From: David [REDACTED]
Sent: 21 January 2022 08:52
To: Kathryn Welch <Kathryn.Welch@arun.gov.uk>
Cc: Architectural Fuller Associates [REDACTED]
Subject: Re: EP/163/21/HH 4 Selhurst Close

As discussed we are looking to recommend refusal of this application based on the garage and it being out of character with the immediate area.

Drawing Name
Ground Floor Plan - Proposed

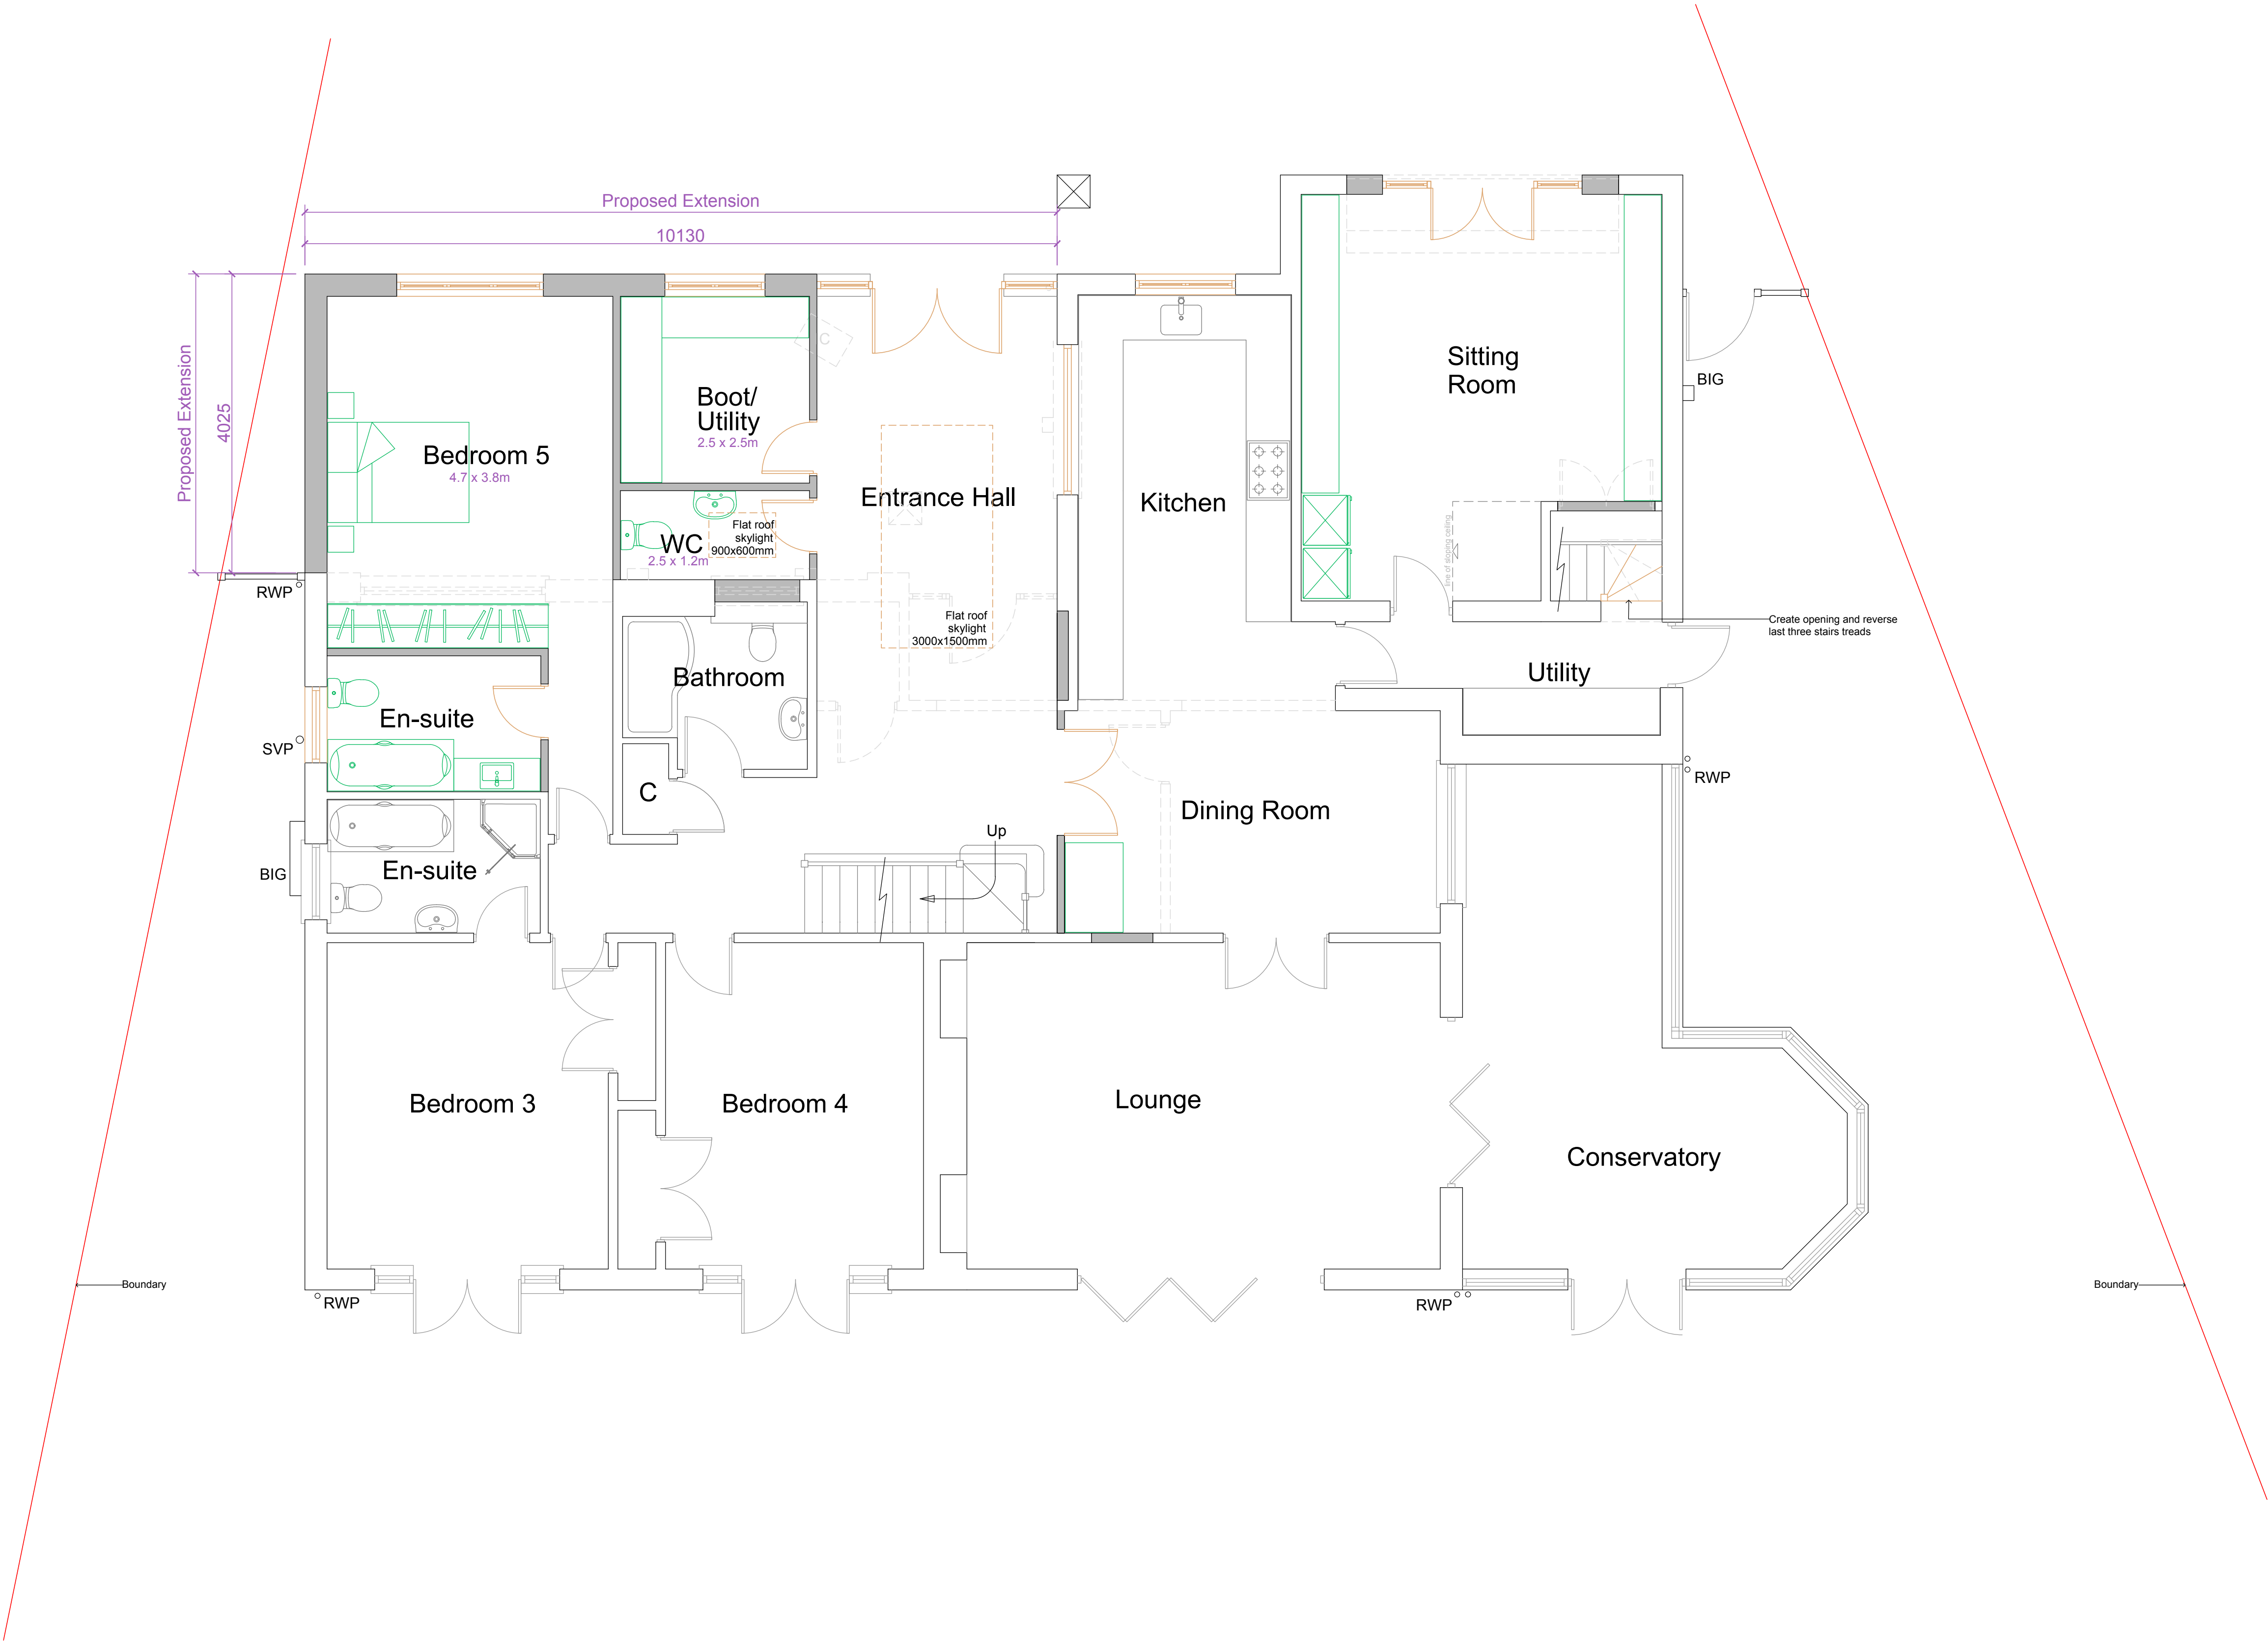
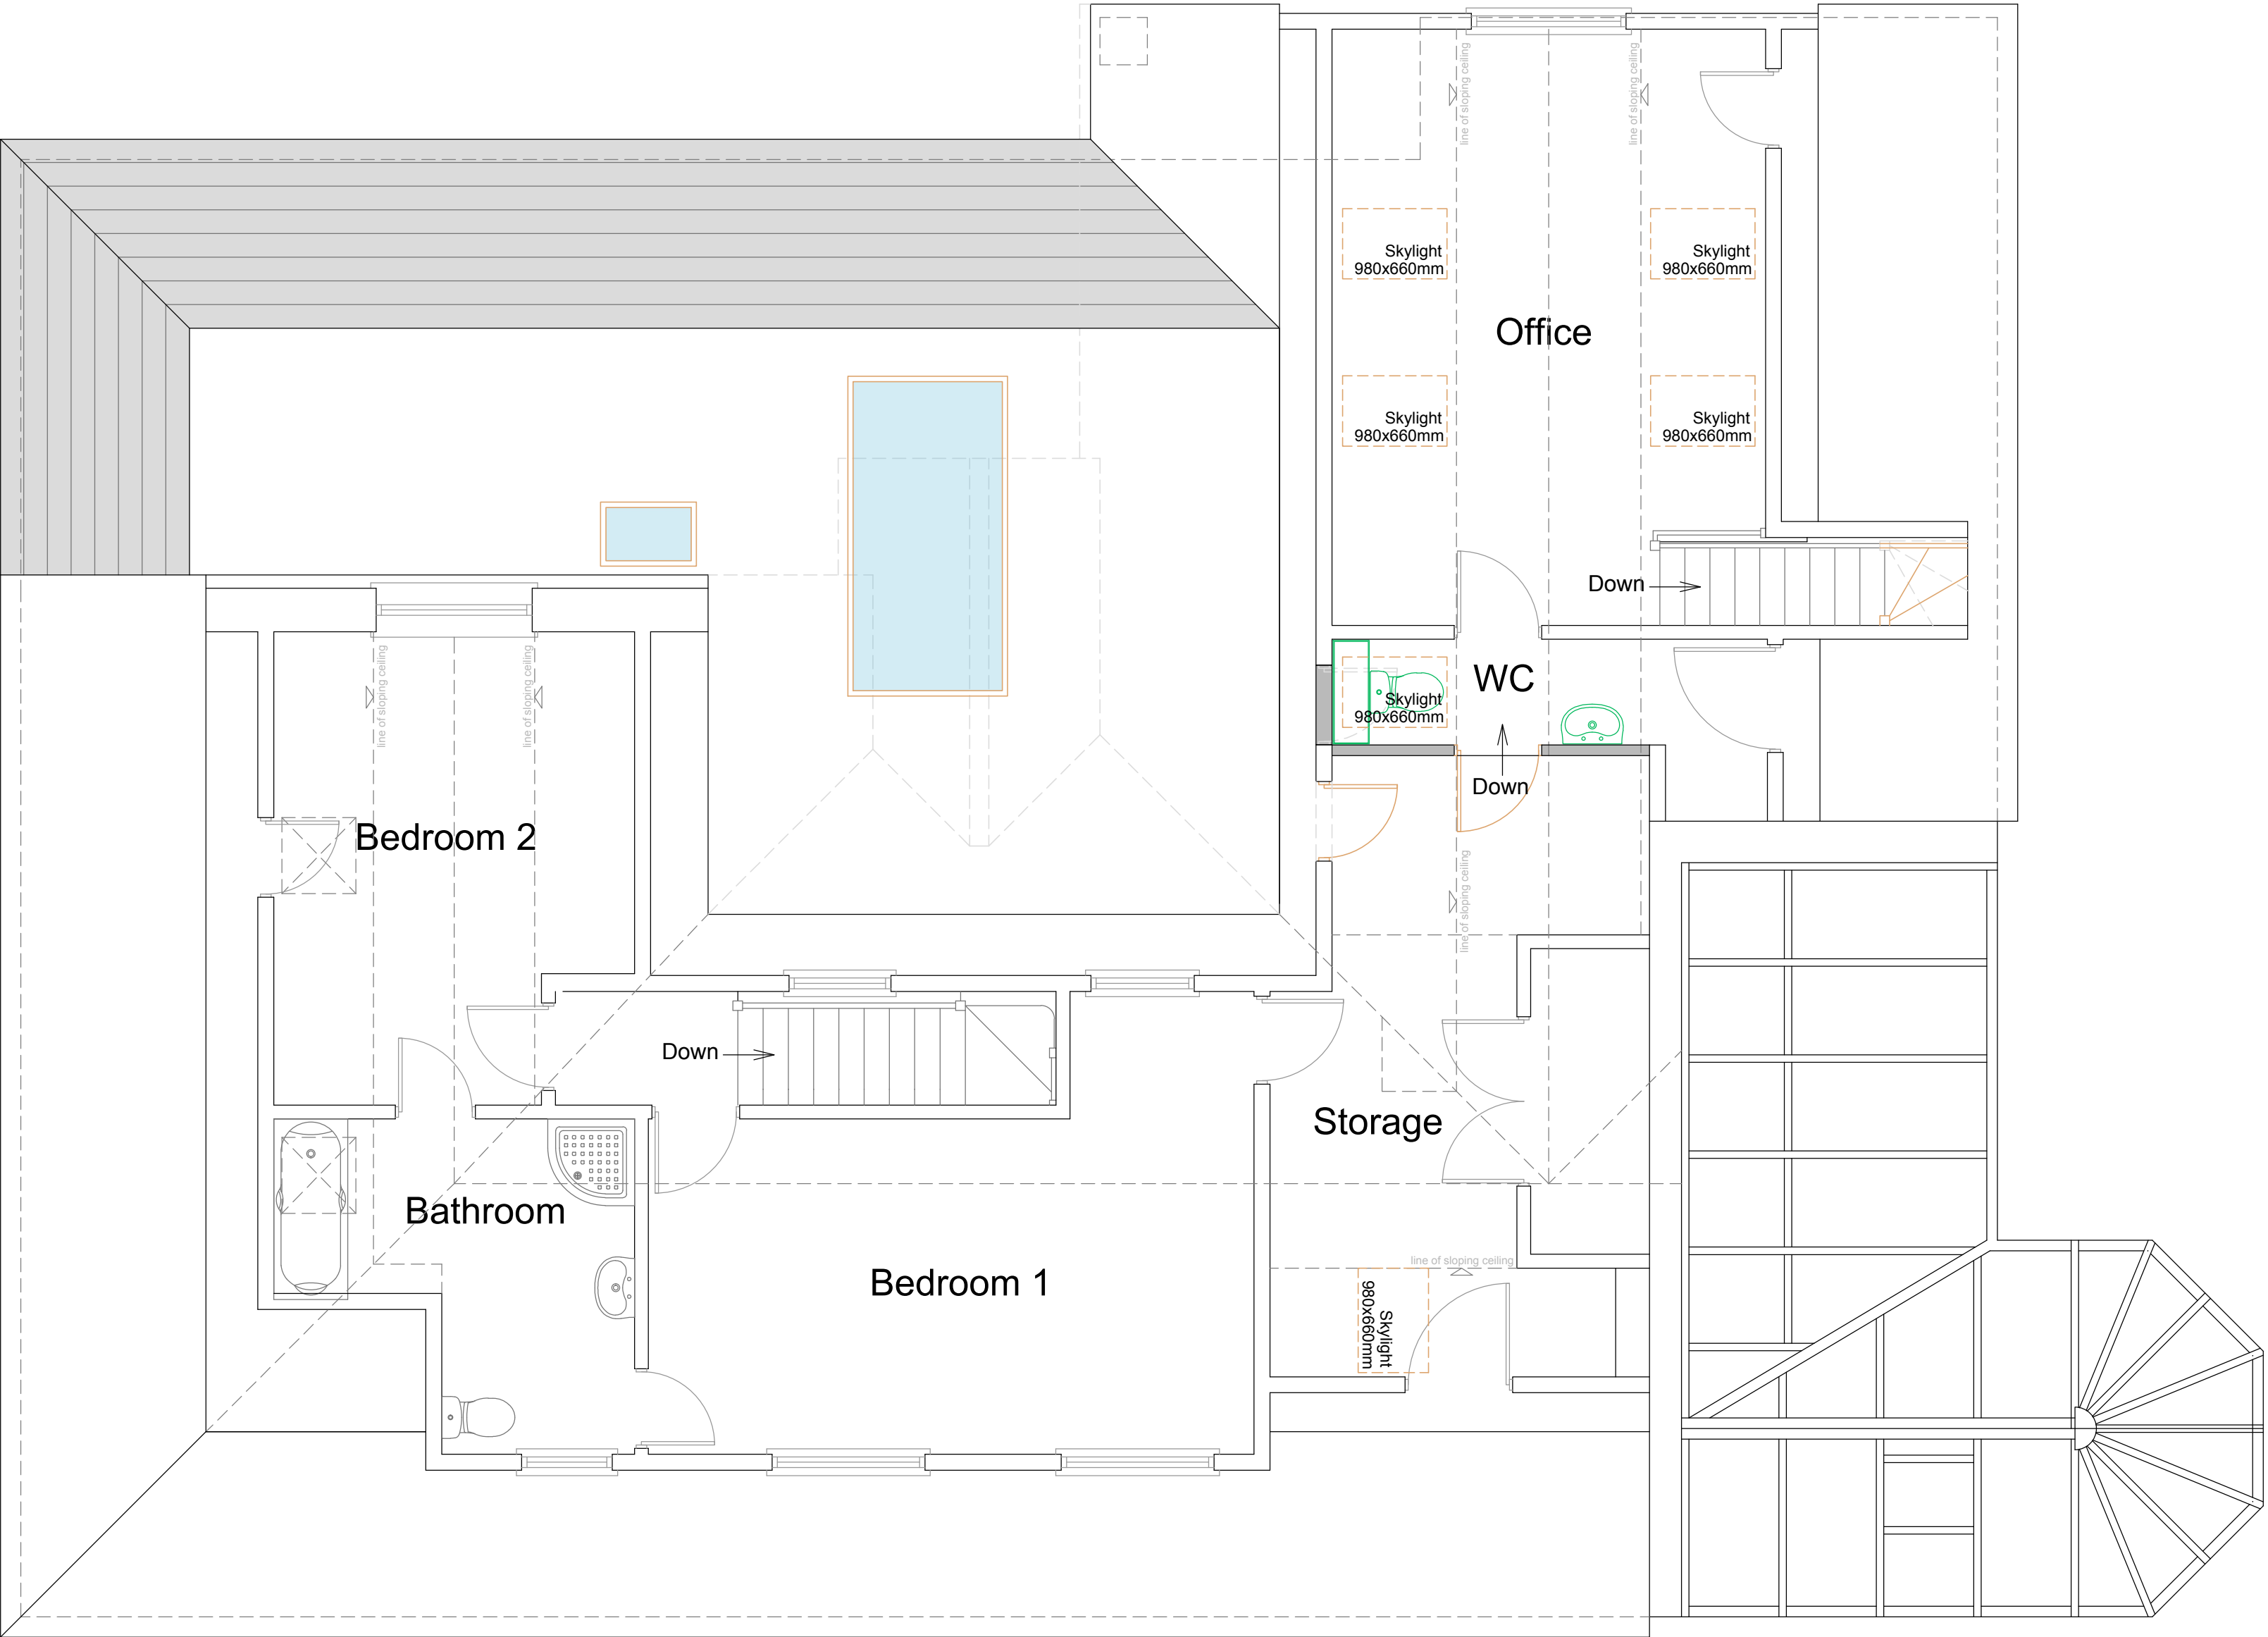
However, it is considered that the extension to the property is considered acceptable. Having viewed the plans I believe the extension to the dwelling to be subservient to the host dwelling, through its appropriate scale and materials choice, and I do not believe it will compromise the spatial character of the area, as the massing of the building is retained. Additionally, I do not believe the extension to be overbearing on neighbouring properties and no negative impact from overlooking is foreseen.
